LSC Responses to EPC Deviation Redline Comments - EBTL at Falcon Hwy&Curtis

Deviation Exhibit

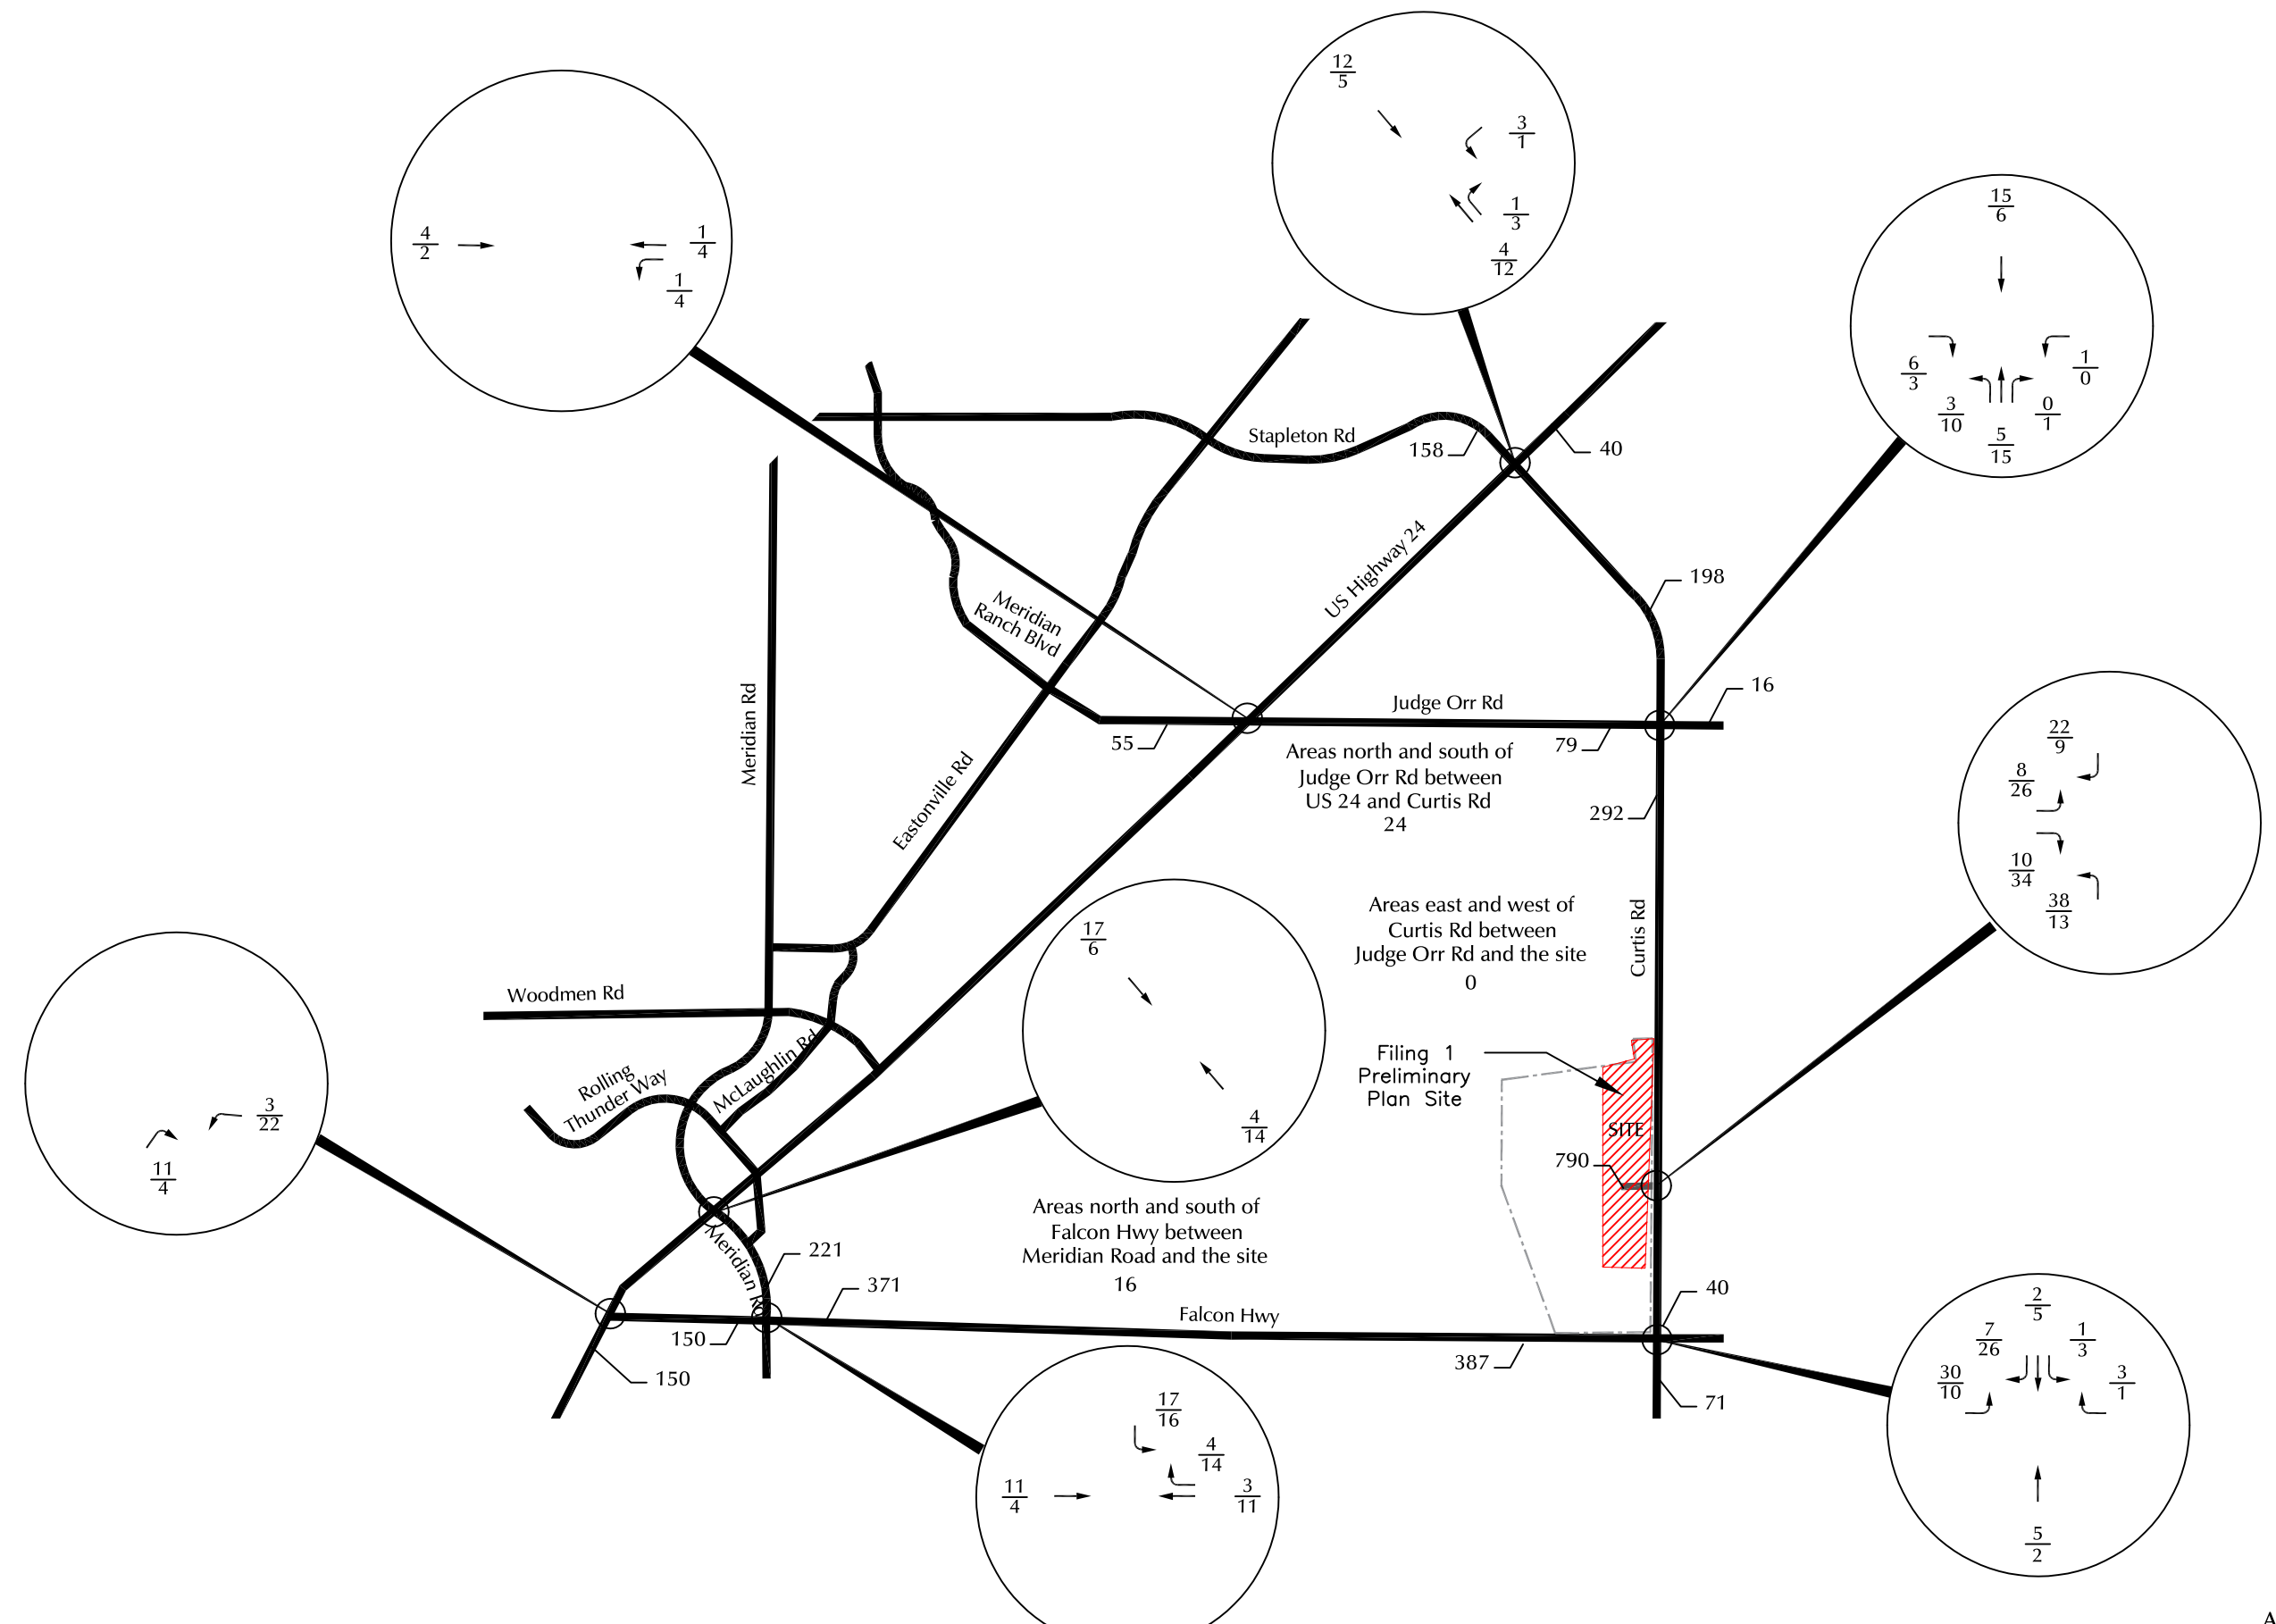
is there any CDOT criteria that may help your justification for keeping the lane as is in the interim?

Please provide further justification as this is not sufficient for approval of this deviation. Identify whether the existing lane can function safely and adequately as is. Recommend that you indicate that this is in line with the condition of approval indicated by staff with Saddlehorn filing 4.

LSC Response: There is some CDOT criteria to support this deviation. The updated deviation contains applicable CDOT Access Code criteria and discussion on the relevance to this request. The CDOT Design Waiver elements are included in the Access Code. Note: A CDOT Design Waiver is somewhat similar to a County Deviation.

LSC Response: The deviation has been updated to address this comment.

A note has been added to clarify that while safety/operations are part of "LIMITS OF CONSIDERATION," the justification elements/details are located within the "CRITERIA FOR APPROVAL" SECTION. This can be further modified, if needed.
